Name	Company	Email
To	Michael Azar	Ecove	michael@ecove.com.au
	Charmaine Pang	Bates Smart	cpang@batesmart.com
	Andrew Brohier	McKenzie Group Consulting	abrohier@mckenzie-group.com.au
Date	04/04/2016	Job no SY150512	Version CA1.4
Project	Site 9 – Sydney Olympic Park

We have prepared this advice to identify and document the fire safety measures that are likely to be required for the proposed residential tower development at Site 9, Sydney Olympic Park to achieve compliance with the performance requirements of the National Construction Code Series 2015 Volume One – Building Code of Australia (BCA)¹. This review is based on the documentation listed in Appendix A.

**General Arrangement Plan  
Level 08**

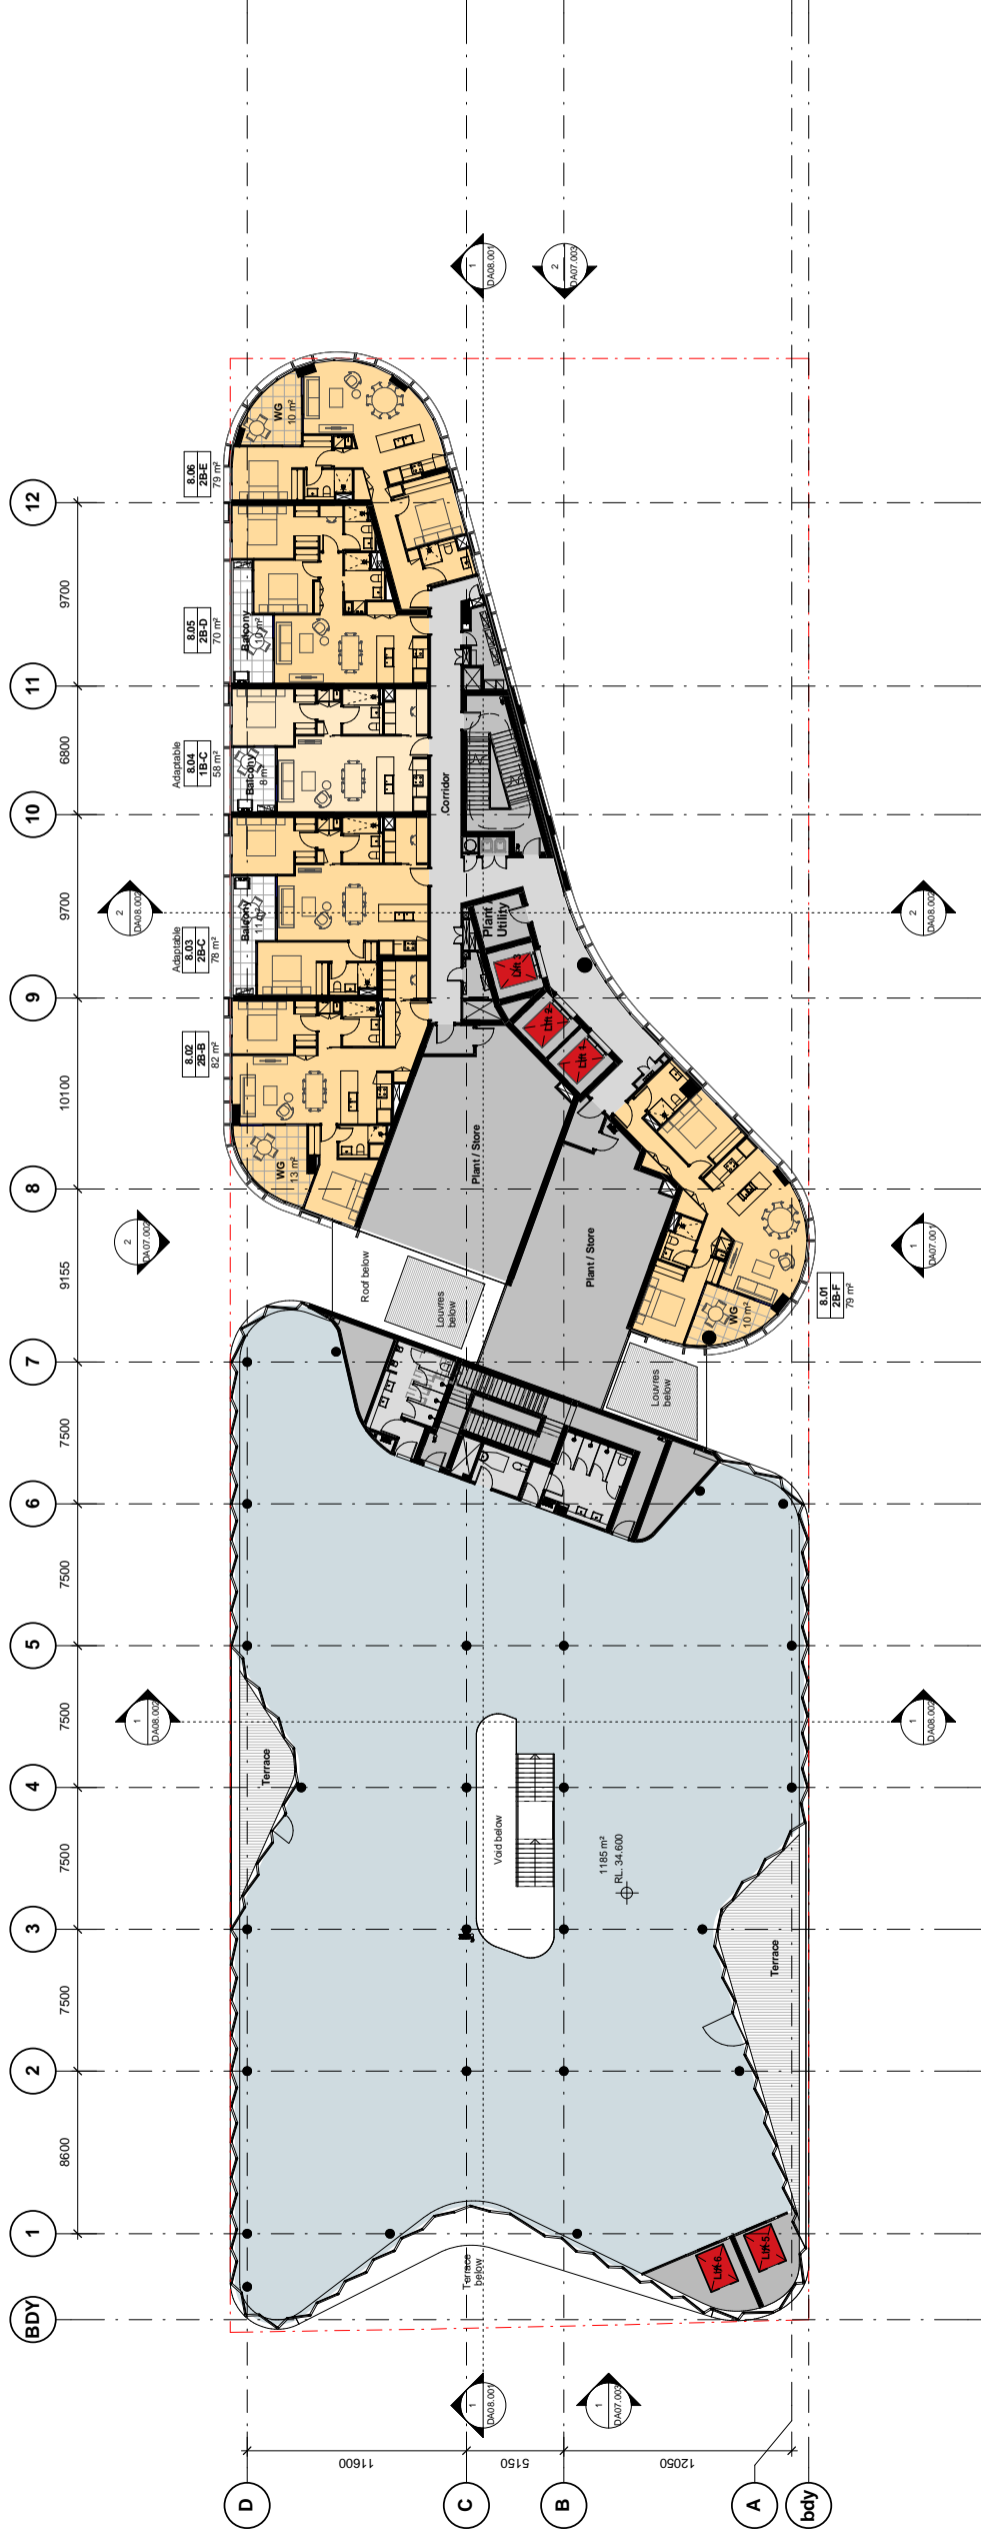
9. The following maximum travel distances apply within the commercial office levels of the building:
- 20m to a single exit or point of choice
 - 50m to the closest of two or more alternative exits including fitout
 - 60m between alternative exits.

11. The maximum travel distance to a point of choice/nearest exit from the plant areas on levels 7 and 8 may be extended to 27m in lieu of 20m.
12. The maximum travel distance to a point of choice/nearest exit from the common area/room on level 9 may be extended to 30m in lieu of 20m.
